**Subject:** Further DOCO comments regarding application number 2026/90421 at location Cockley Hill Lane, Kirkheaton, Huddersfield, HD5 0HH - cycle storage details

Re: condition 13- amended cycle storage details

I have reviewed the newly submitted document “Gleeson Homes Standard Details – Cycle Shed Dwg Ref: SD05” (id 1136488).

Standard Details – Cycle Shed Dwg Ref: SD05

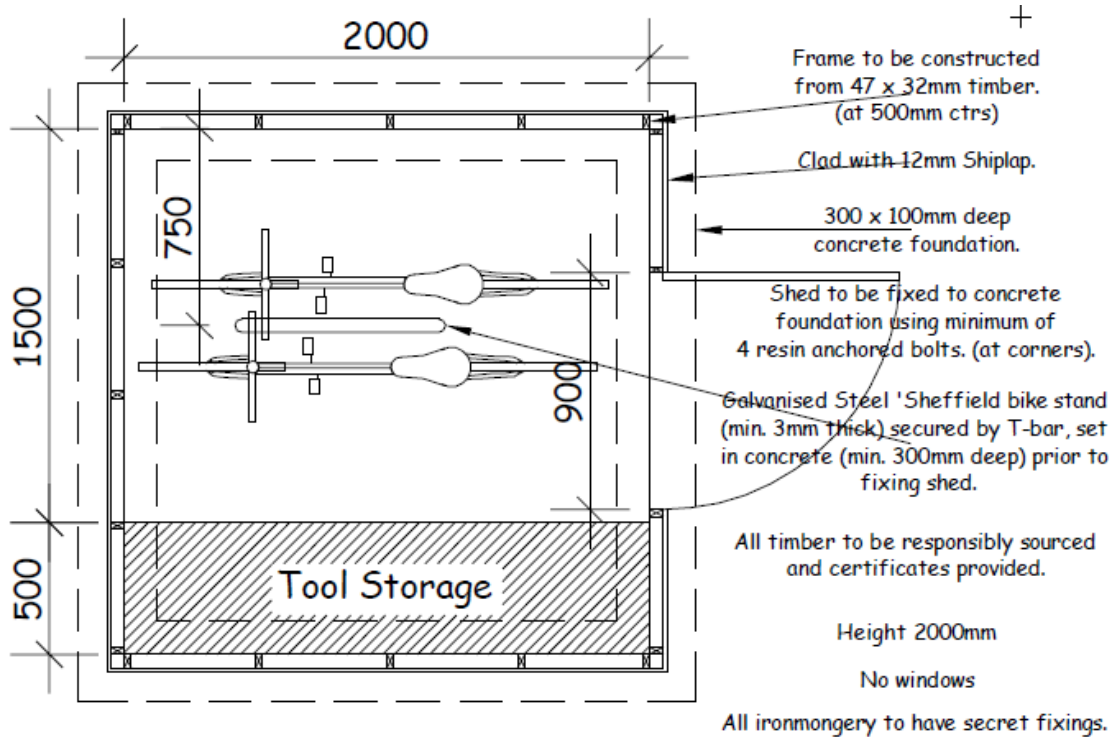
Could the applicant please be advised to consider installing Sheffield stands which are security rated to one of the standards mentioned in previous correspondence (Sold Secure SS104 Bronze, LPS 1175 Issue 8 Security Rating A1, STS 225 Issue 2 Burglar Resistance BR1(S), STS 205 Issue 8 Burglar Resistance BR1, STS 501 Security Rating TR1 or STS 503 Security Rating TR1).

The condition can be discharged.
